**Addendum No. 1**

RE: Contract # C204727

**Robeson County (I-5987A)**

I-95 FROM SOUTH OF US-301 TO SOUTH OF NC-20.

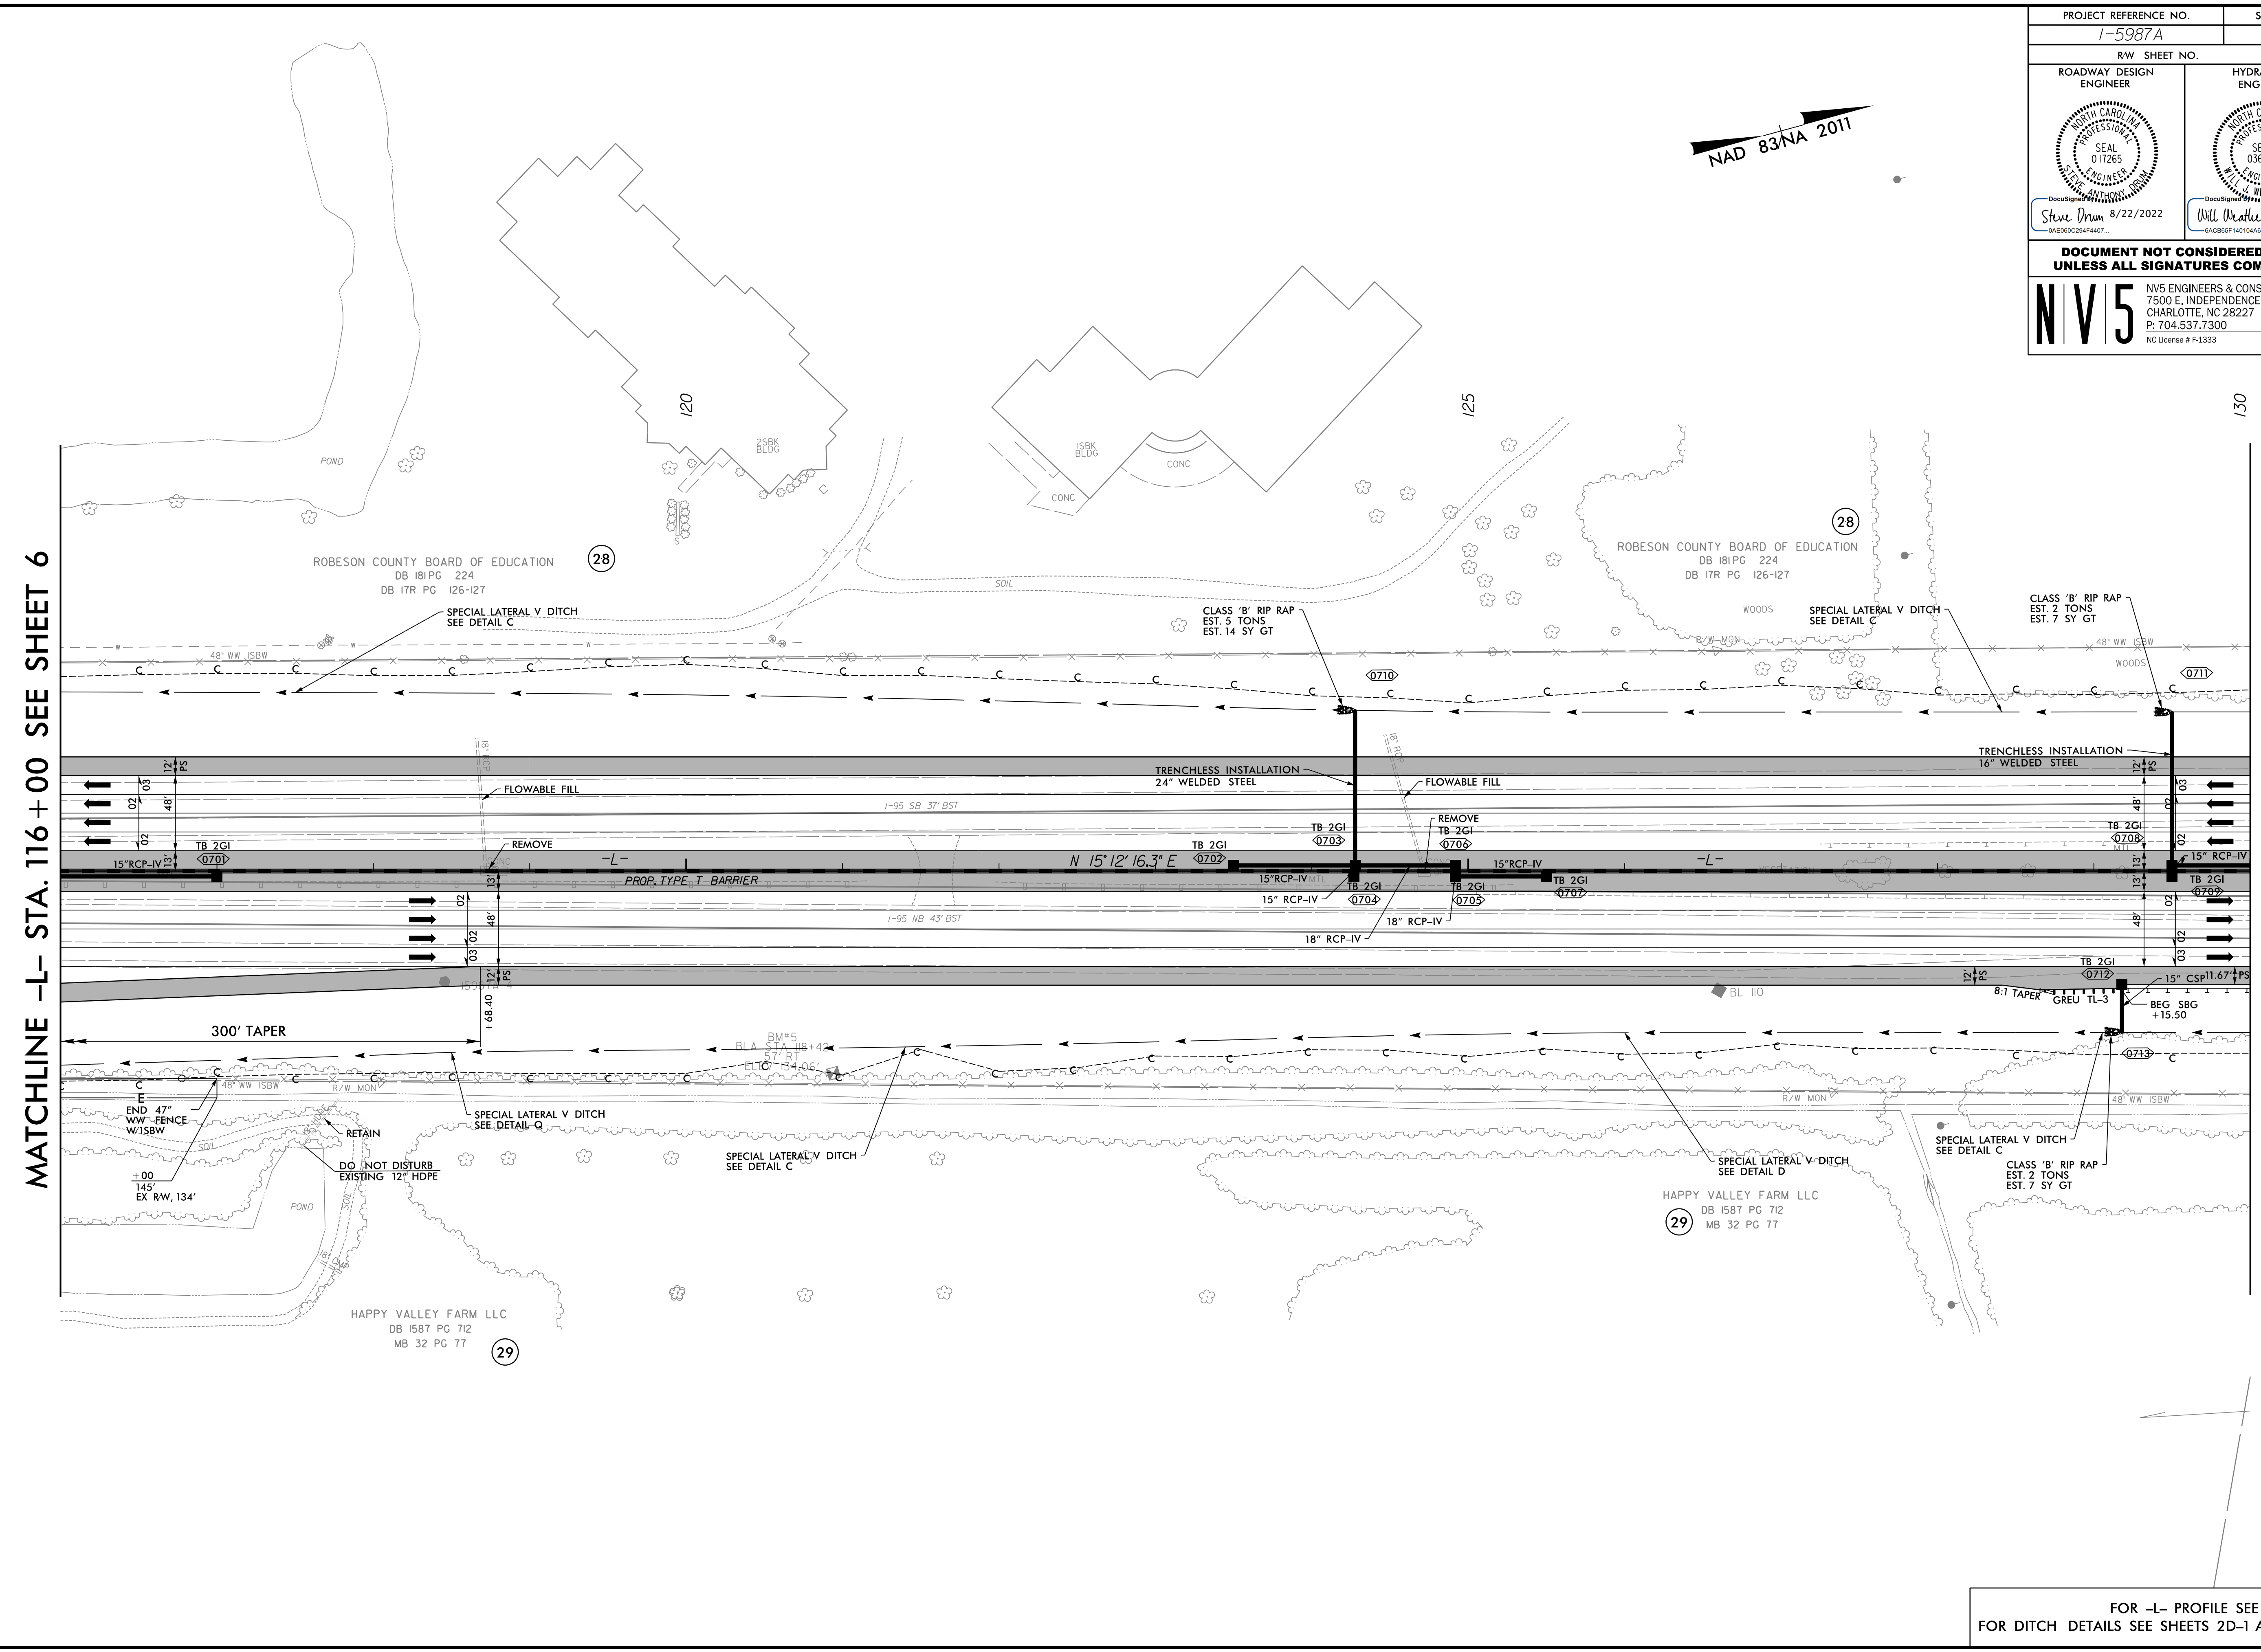
Sheet No.	Revision
6	Added Existing 18" RCP and Riser Sta 113+50+/- RT for the existing pond on Parcel 29. Added "Retain" and "Do Not Disturb" notes on Parcel 29.
7	Added Existing 12" HDPE Sta 117+80+/- RT for the existing pond on Parcel 29. Added "Retain" and "Do Not Disturb" notes on Parcel 29.

CLEARING AND GRUBBING
 EROSION CONTROL FOR
 CONSTRUCTION SHEET 7

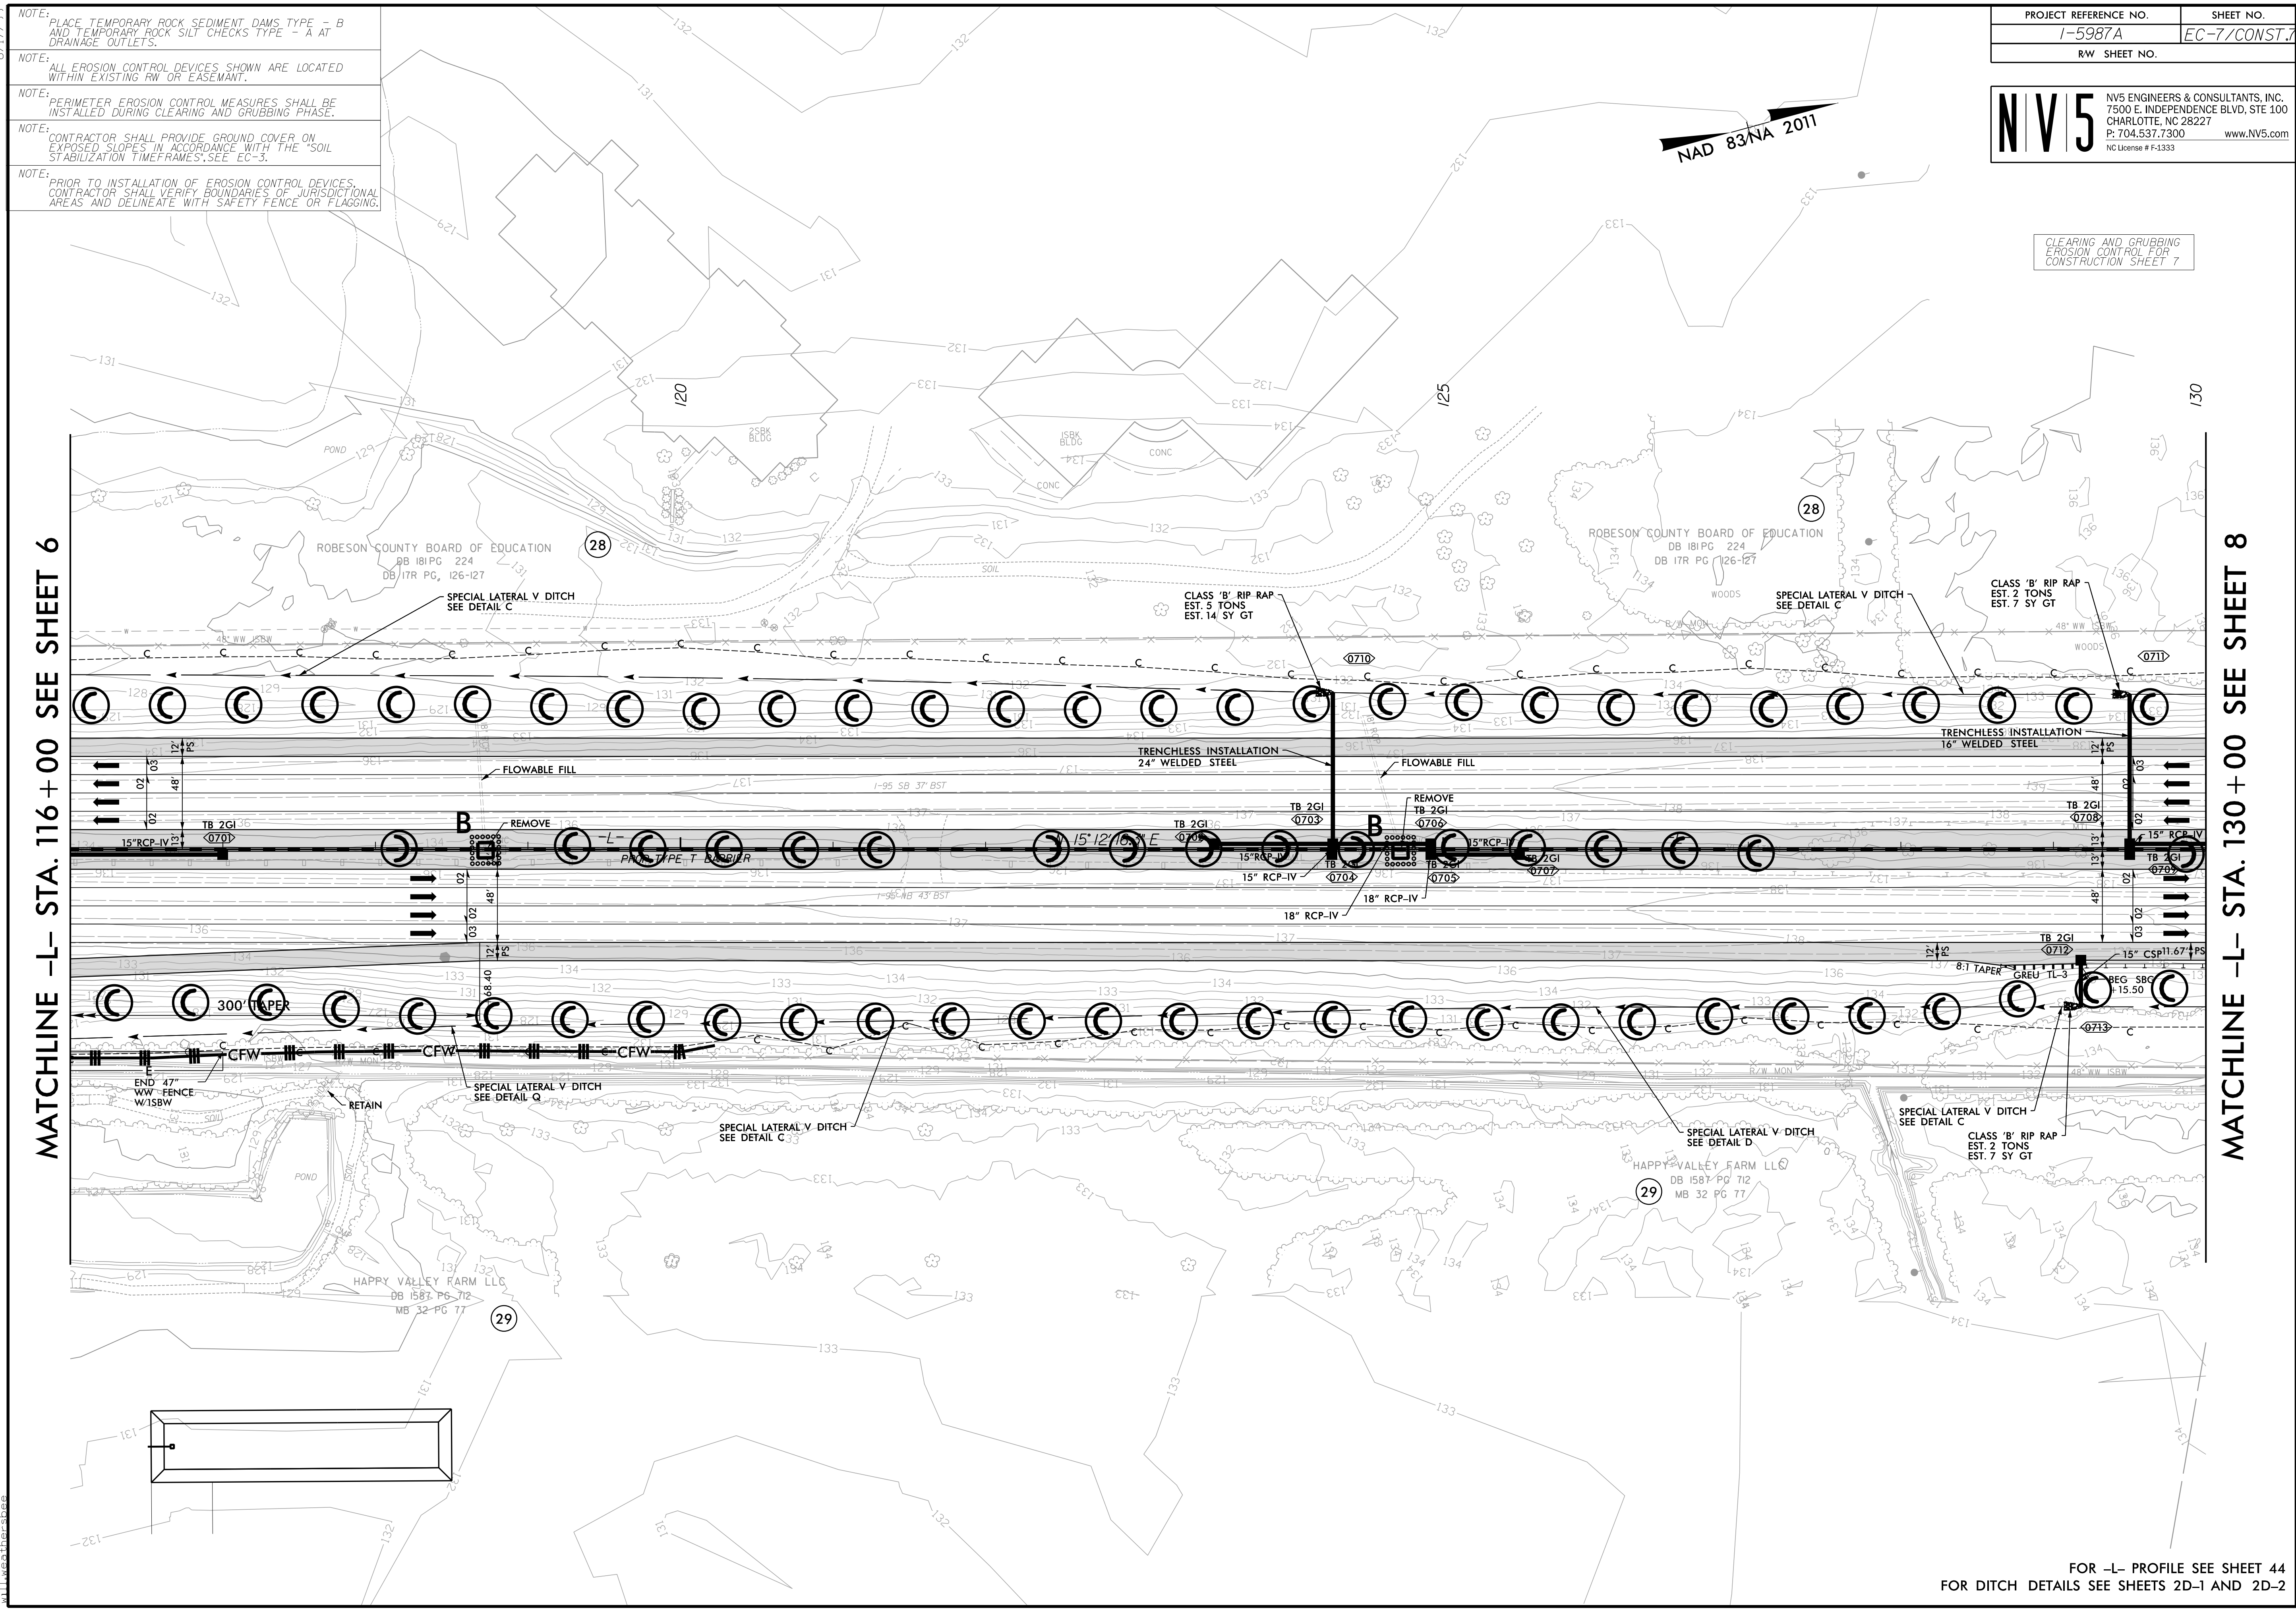
Sheet No.	Revision
EC-6, EC-42	Added existing 18" RCP and riser at Sta 113+50+/- RT for the existing pond and added "Retain" note. Adjusted proposed skimmer to avoid impact with existing 18" pipe, and added a temporary rock silt check type A with PAM.
EC-7, EC-43	Added existing 12" HDPE at Sta 117+80+/- RT for the existing pond and added "Retain" note.
